Ecological comments

Planning Application No: **3/2012/0402**

Proposals: **Erection of a 50kW wind turbine (34.2m to tip height) to supply electricity to the farming operations**

Location: **Mason House Farm**

Endurance E-3120 50kw Turbine
Location plan 1:2,500 Block Plan 1:500

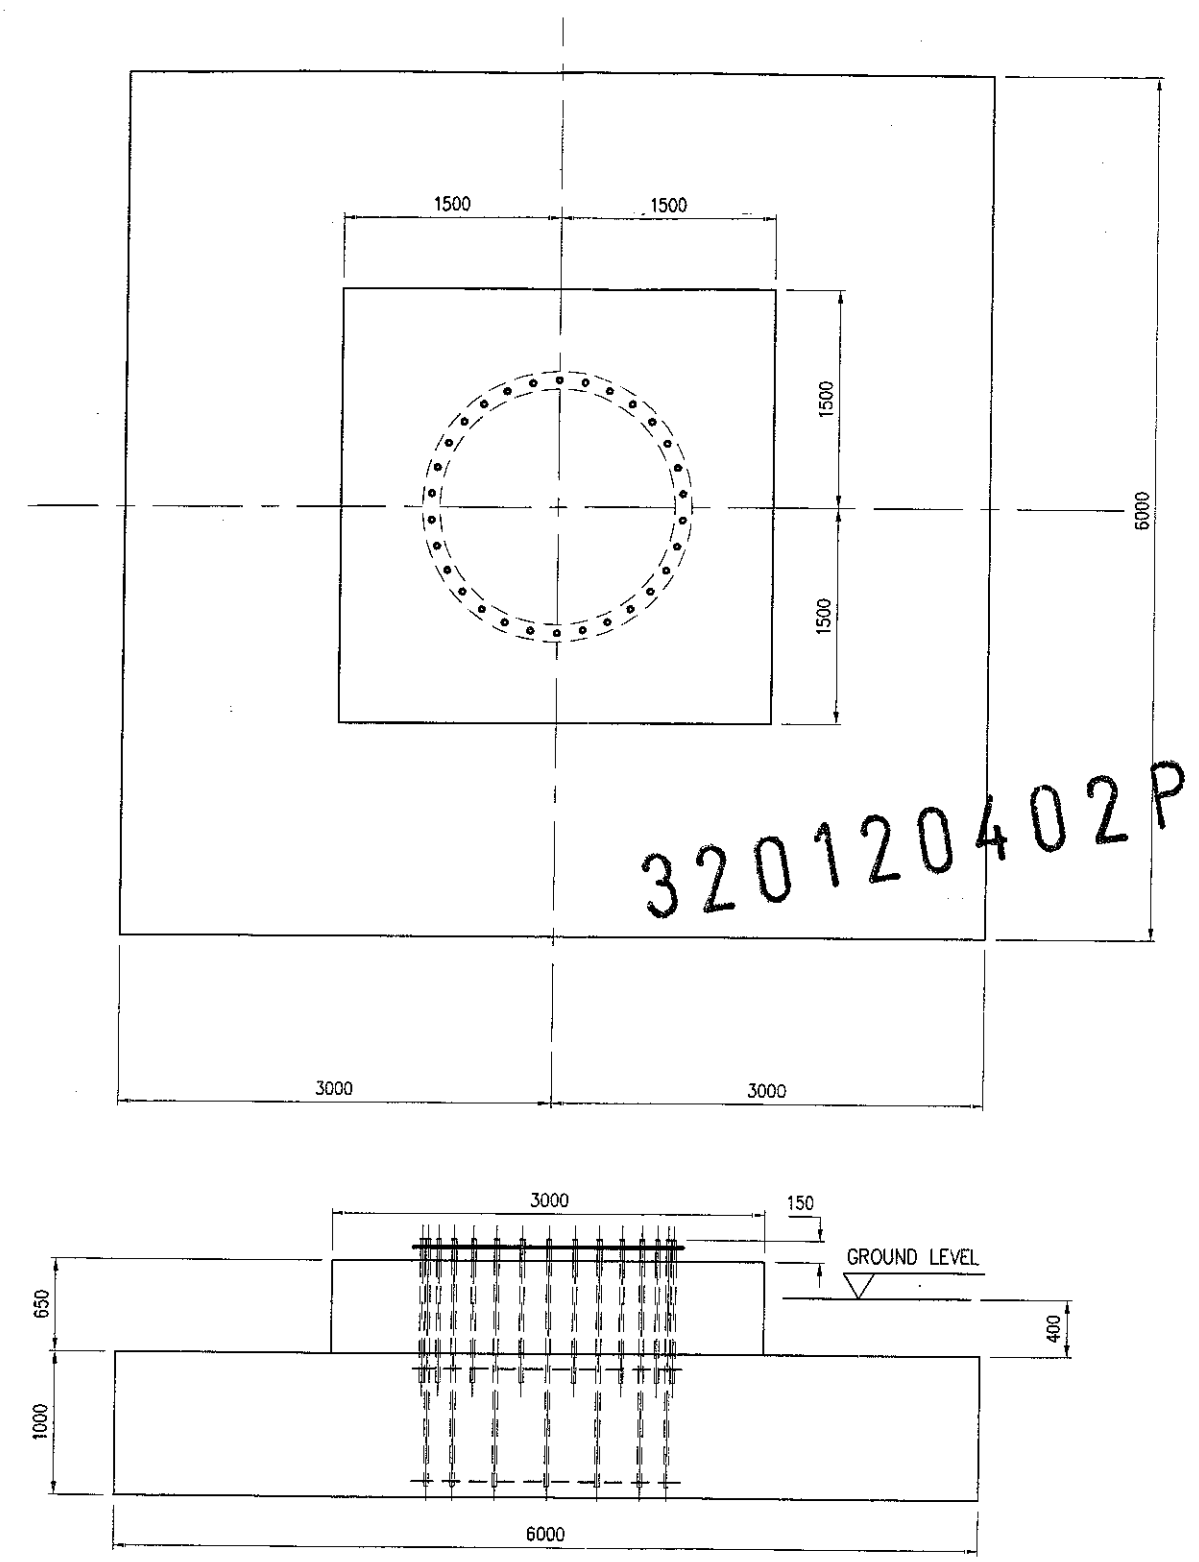
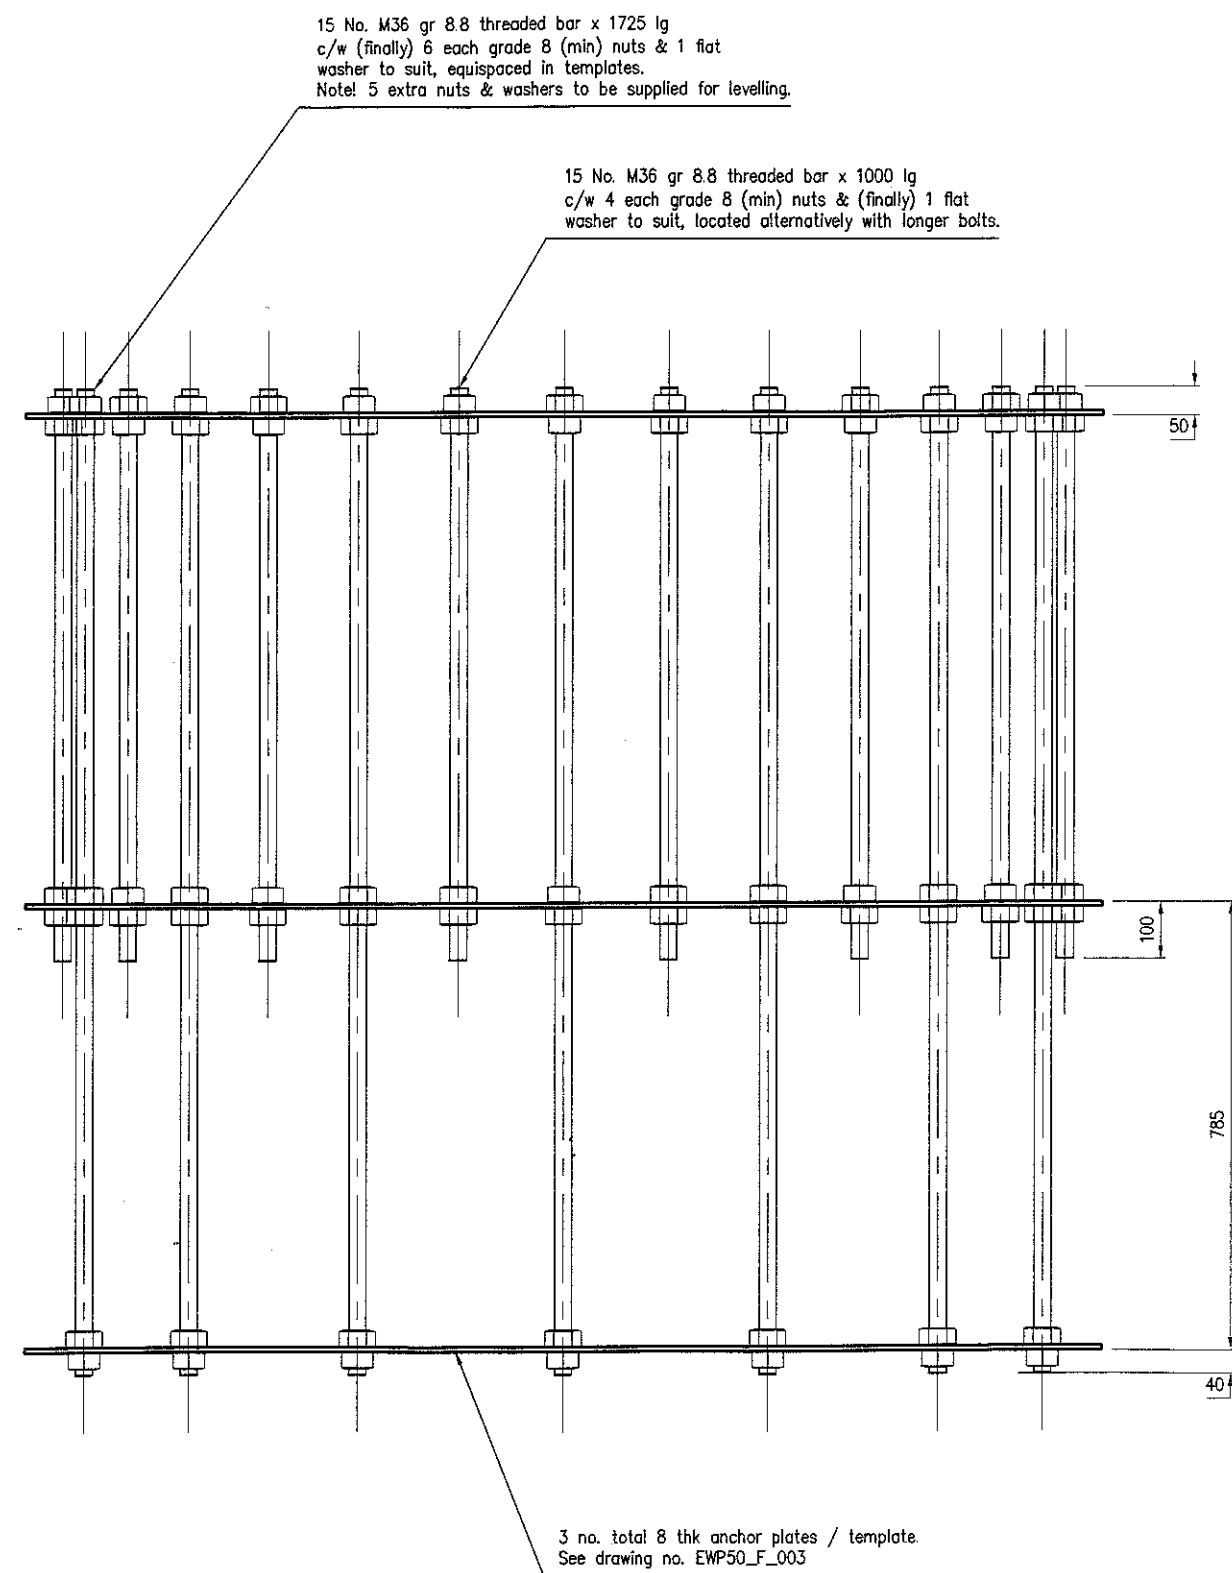
- The proposed turbine tips appear to fall within 50 metres of a hedgerow feature that may be used by bats. Unless the turbine can be relocated to retain a buffer of at least 50m from blade tip to features with potential to be used by bats further information will need to be provided before the application if determined (see below).

Although the submitted plan shows the proposed turbine base is located 50m from the hedgerow to the west, based on the grid reference provided in the Application Form the turbine base appears to be closer than this at approximately 46m. In addition the proposed turbine blades appear to be 9.6m which would likely result in the blade tips sweeping closer than this to the hedgerow. Bats may use this hedgerow for foraging / commuting. Natural England advises that in order to avoid impacts on bats a buffer of at least 50m should be maintained between features likely to be used by bats and the blade tip of turbines. If the blade tips of the proposed turbine would not fall within 50m of features which have the potential to be used by bats (such as trees, buildings, waterbodies, linear features such as hedgerows, tree lines, ditches and stone walls connecting suitable bat habitat, and other suitable foraging habitat etc) then no bat survey will be required. Otherwise, an assessment of likely impacts on bats, potentially including bat activity surveys, will need to be undertaken before the application is determined. When assessing likely impacts on bats, Natural England Guidance notes TIN 059 and 051 should be taken into account.
